**RE: 4600 Edith Blvd NE – SWMD Admin. Office and Vehicle Maintenance
Conceptual G&D Plan (Engineer's Stamp 3/9/2020)
Hydrology File: G15D202**

Based upon the supplemental information provided in your submittal received 3/30/2020, the Conceptual Grading and Drainage Plan is approved for Site Plan. For Building Permit or Work Order an approved final Grading and Drainage Plan will be required. Below are comments to address what needs to be completed for final Grading and Drainage Plan approval.

CONCEPTUAL GRADING & DRAINAGE PLAN

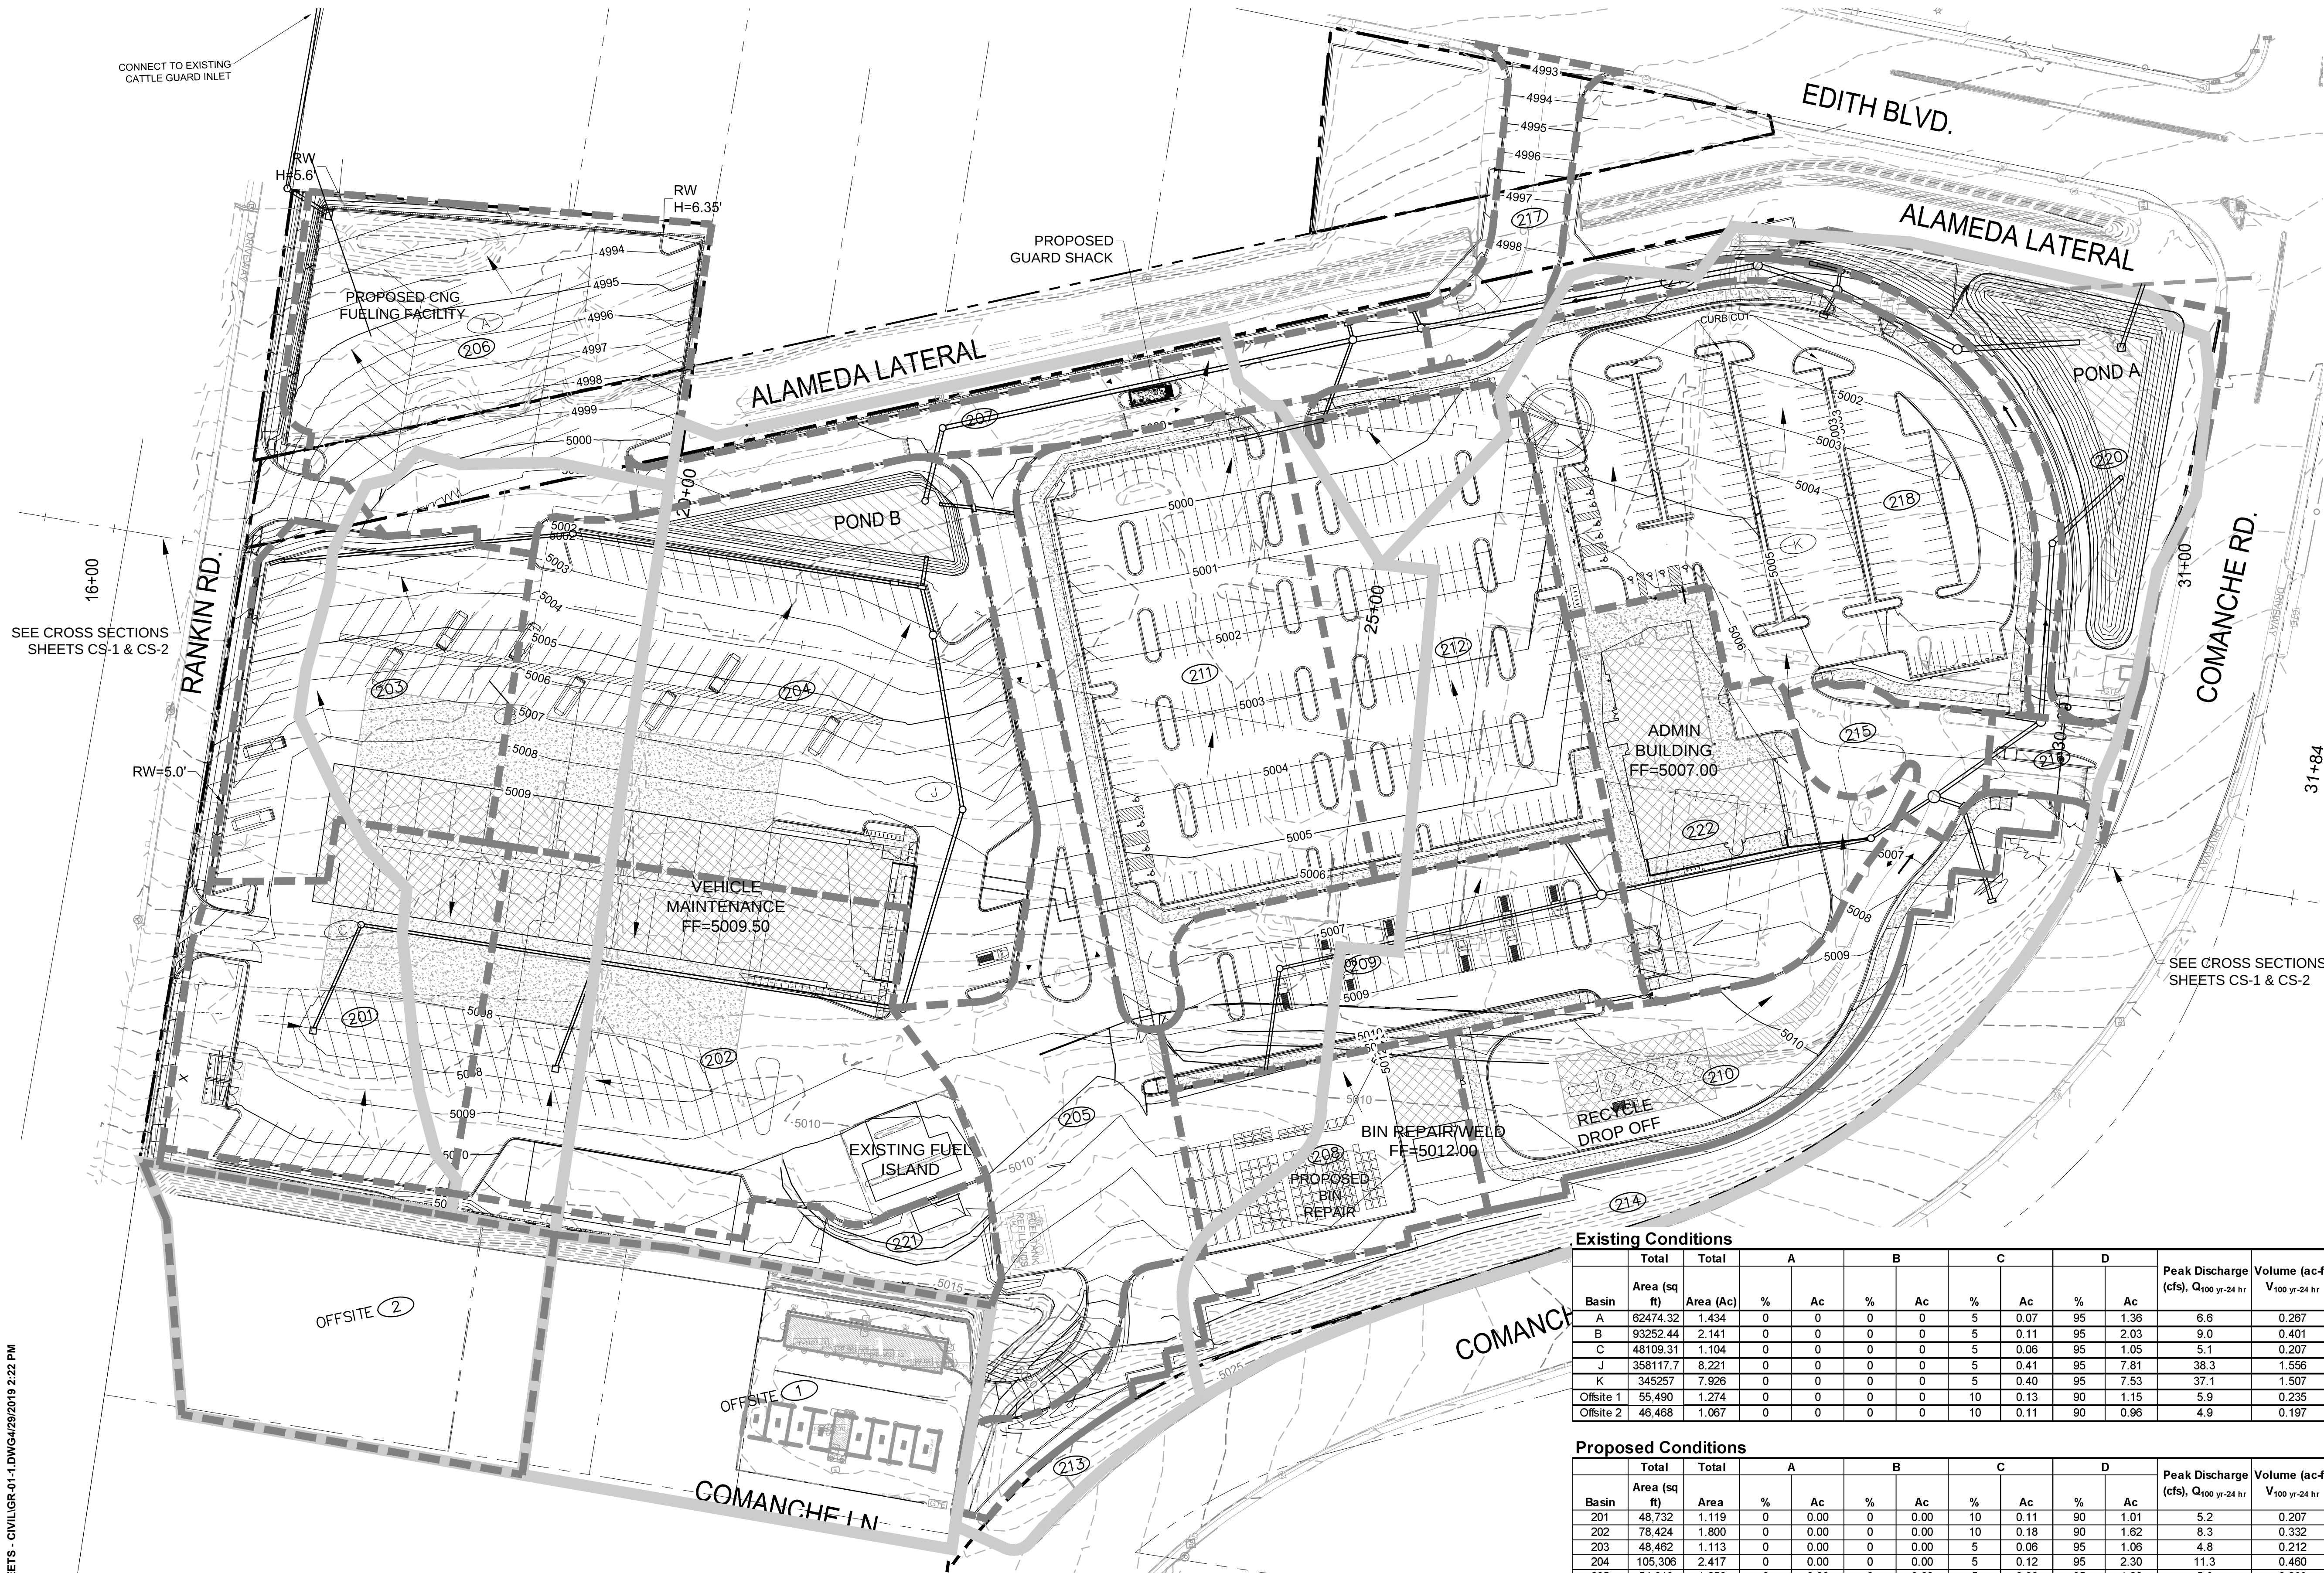
1. Remove the label "Not for Construction" from the G&D Plan. Include an overall sheet like the Conceptual G&D Plan and provide a detailed design at a larger scale on multiple 24' x 36" sheets including many more spot elevations and details of the ponds.

3. Please add typical section of Rankin Road to the G&D Plan and include dimensions from the face of curb and sidewalk to the new right of way line. Also provide a typical section of the slope/retaining wall at the west end of the Rankin Rd frontage between the sidewalk and parking lot. The Retaining wall must not encroach into the public right of way.

4. Please provide details for Pond C, including placement details and elevations. Also include details for the water quality inlet and pipe to underground storage including profiles.

5. Please provide construction specifications and details on the G&D Plan for all of the hydraulic structures (build notes). Label the pipes, inlets, and manholes. The numbering system (nodes) in the calculations should be shown legibly on the G&D Plan both the overall plan and the more detailed sheets. The exhibit in the report is not legible.

7. The numbering of Pond A and B on the G&D Plan does not agree with the labels in the AHYMO files, please fix the labels in AHYMO. Pond B, on the G&D Plan, appears to have an extended detention volume of 3' depth which can be counted as the BMP/SWQV if the pond will drain in 48 hr or more at the average release rate calculated for the average pond depth (1.5'?). Please provide separate SWQV calculations for the area draining to each BMP.

8. How were the AHYMO pond routing input tables developed?
 - a. Details of the pond outfall structures are required on the G&D Plans for construction.
 - b. A narrative description of the pond outfall hydraulic calculations is also needed with the calculations.

- c. Provide pond volume calculations using the conic method showing the area of the contours used in the volume calculations.
9. The hydraulic HGL calculations for the on-site storm drains could not be checked because the pipe and inlet numbers are not shown on a map anywhere. Please add the pipe, inlet and MH labels to the overall G&D Plan and add the EGL to the output data table.

10. Please specify the Curb type/height on the G&D Plan and be sure that the 100 year flow depths do not overtop the curb particularly on the curbs carrying a lot of flow running north and south along the west edge. Especially consider specifying 8" STD C&G in the vicinity of curb opening inlets.

11. Typical sections should be shown at numerous locations around the perimeter of the site. Each section should show the property line, both the existing and proposed grades, slopes and walls with dimensions, both horizontal and vertical, as necessary to demonstrate compliance with DPM 22.5.B
